**Approval of details reserved by condition imposed under ref APP/C3810/W/19/3232525 (FG/35/19/PL)
relating to Condition No 2 - surface water drainage.**

Quercus Nursery Littlehampton Road Ferring BN12 6PG

Arun District Council have decided to **REFUSE details reserved by condition for the following reasons:**

PROPOSED DRAINAGE LAYOUT
AND DETAILS

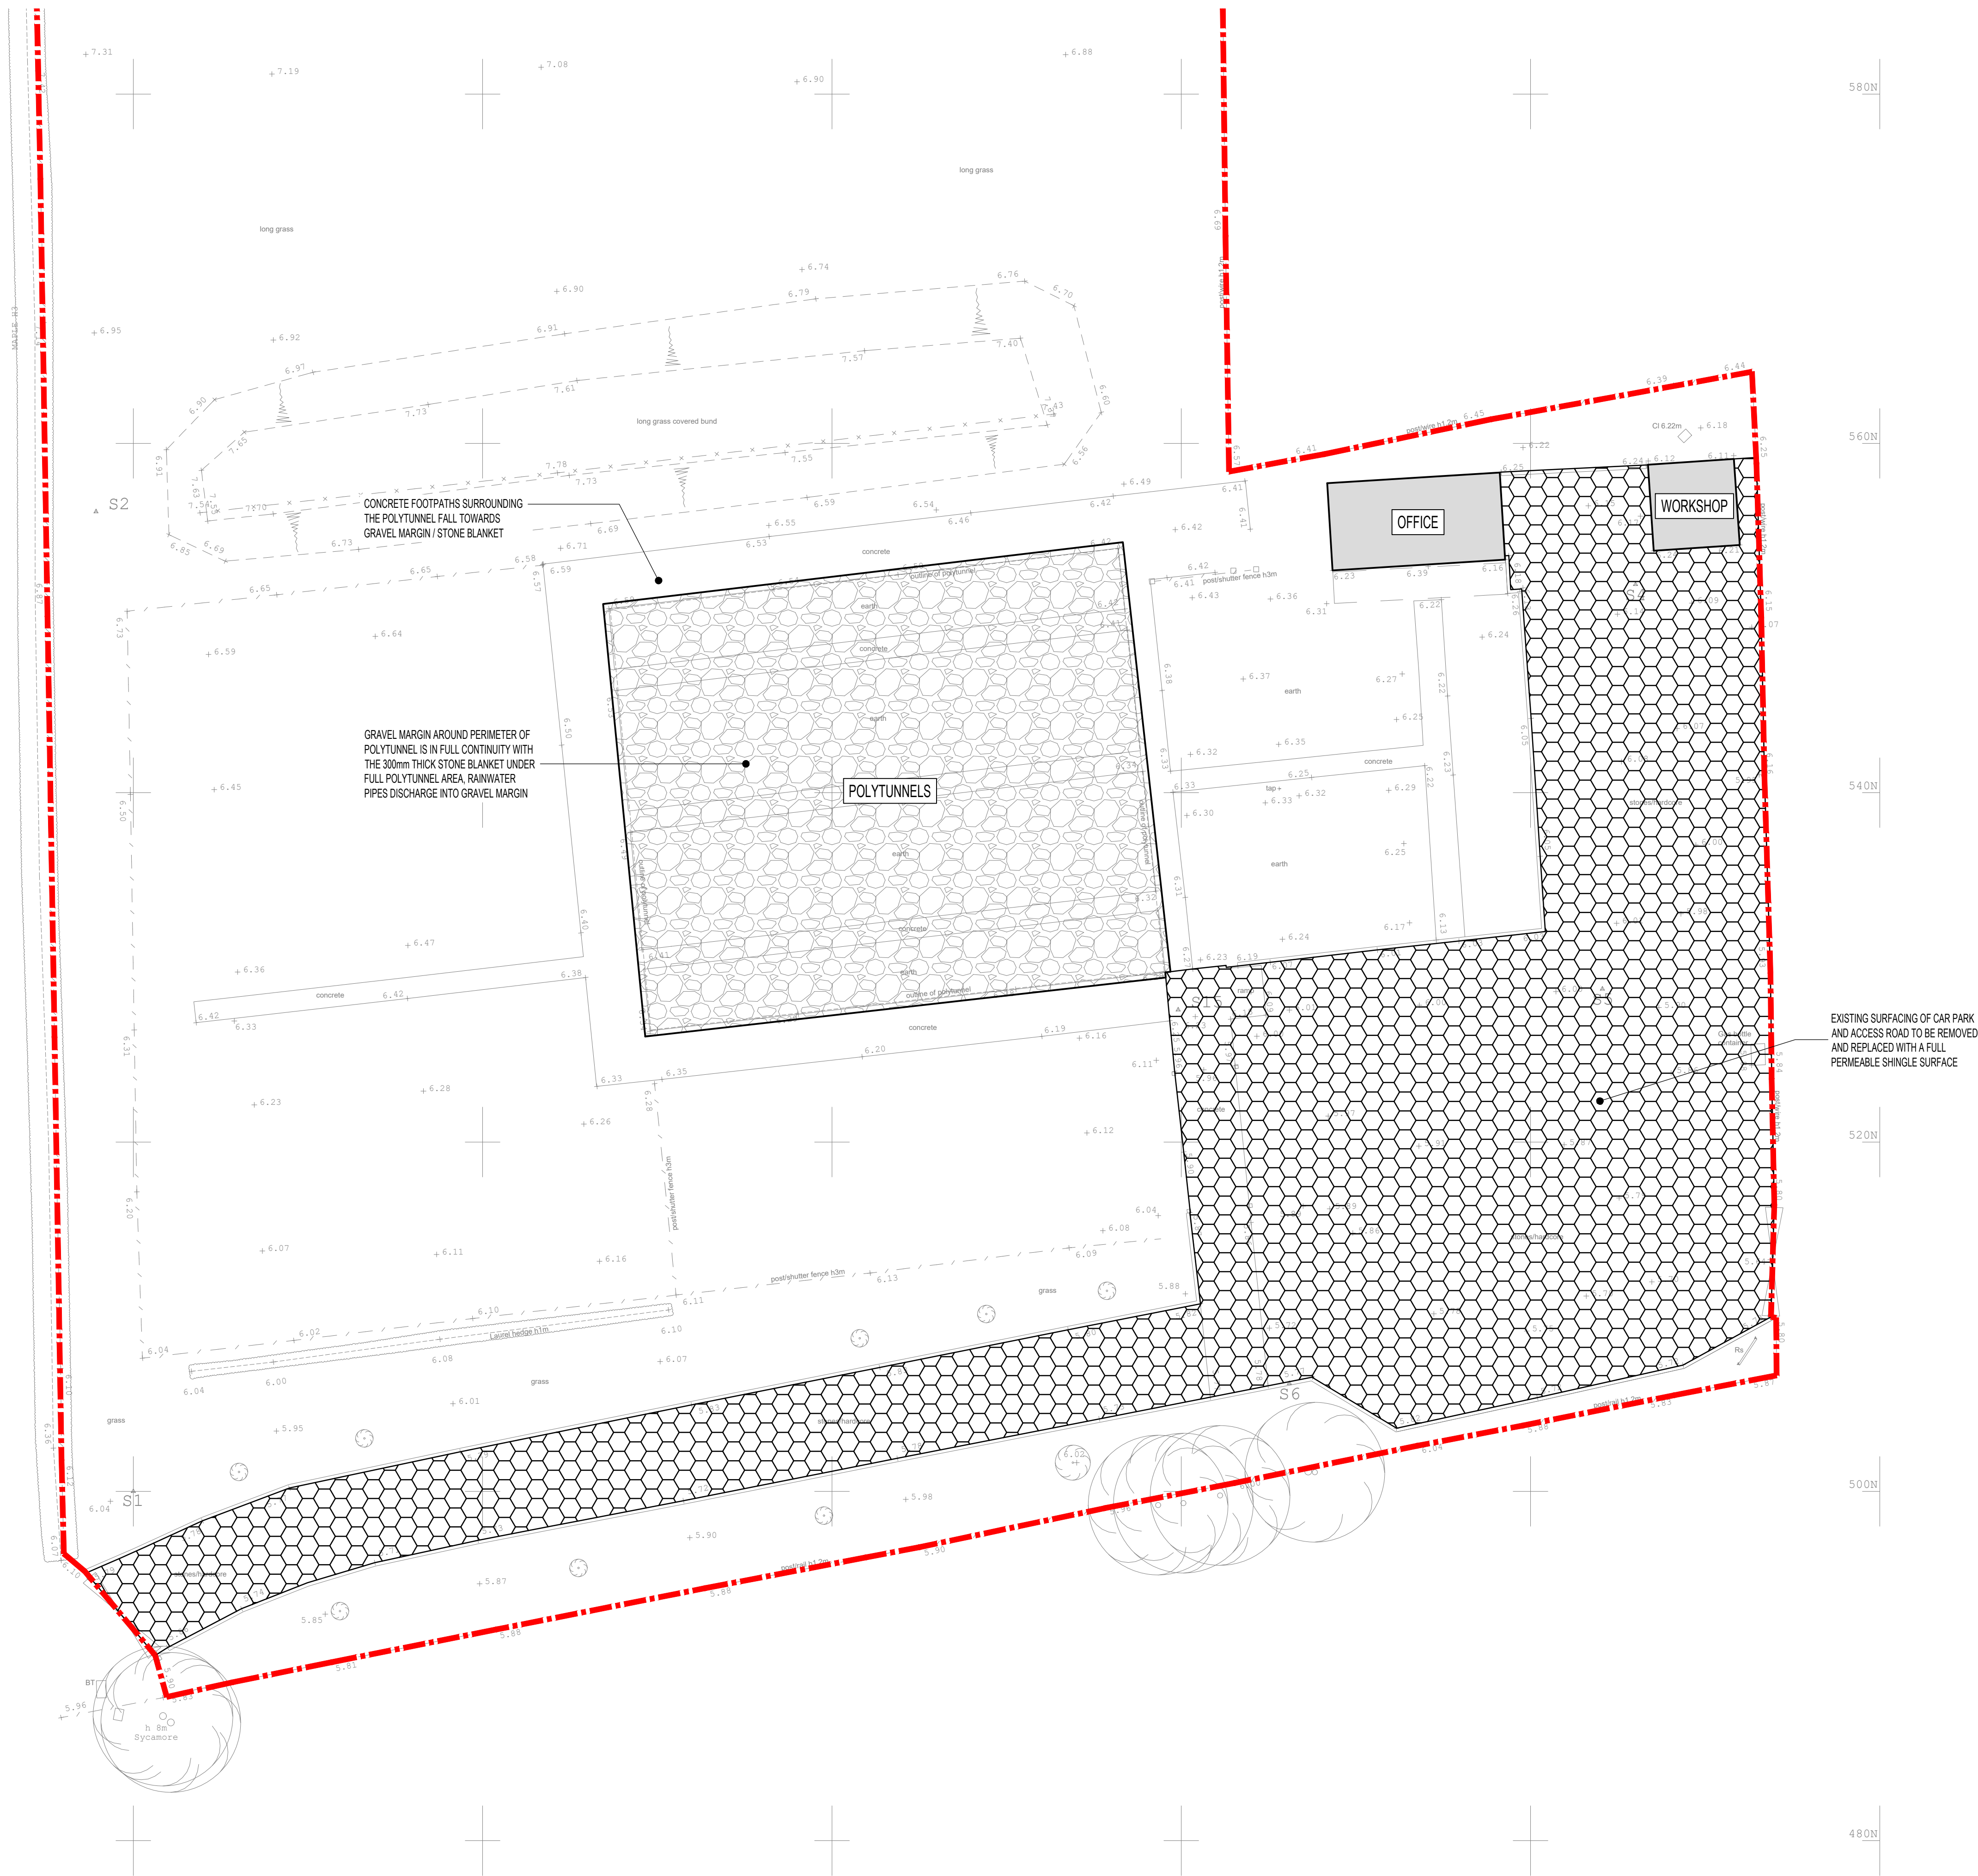
1. Infiltration testing was completed too deep and not in accordance with BRE365. One test was completed in each location only, and water failed to drain to 25% level. The infiltration tests were completed below groundwater level and not at the depth of the proposed infiltrating features.
2. No calculations have been supplied to support the design.
3. No construction detail drawings have been provided.
4. The layout plan does not detail the required depth of the car park sub-base.
5. The layout plan needs to clearly state whether permeable storage areas are to have flat sub-bases or not.
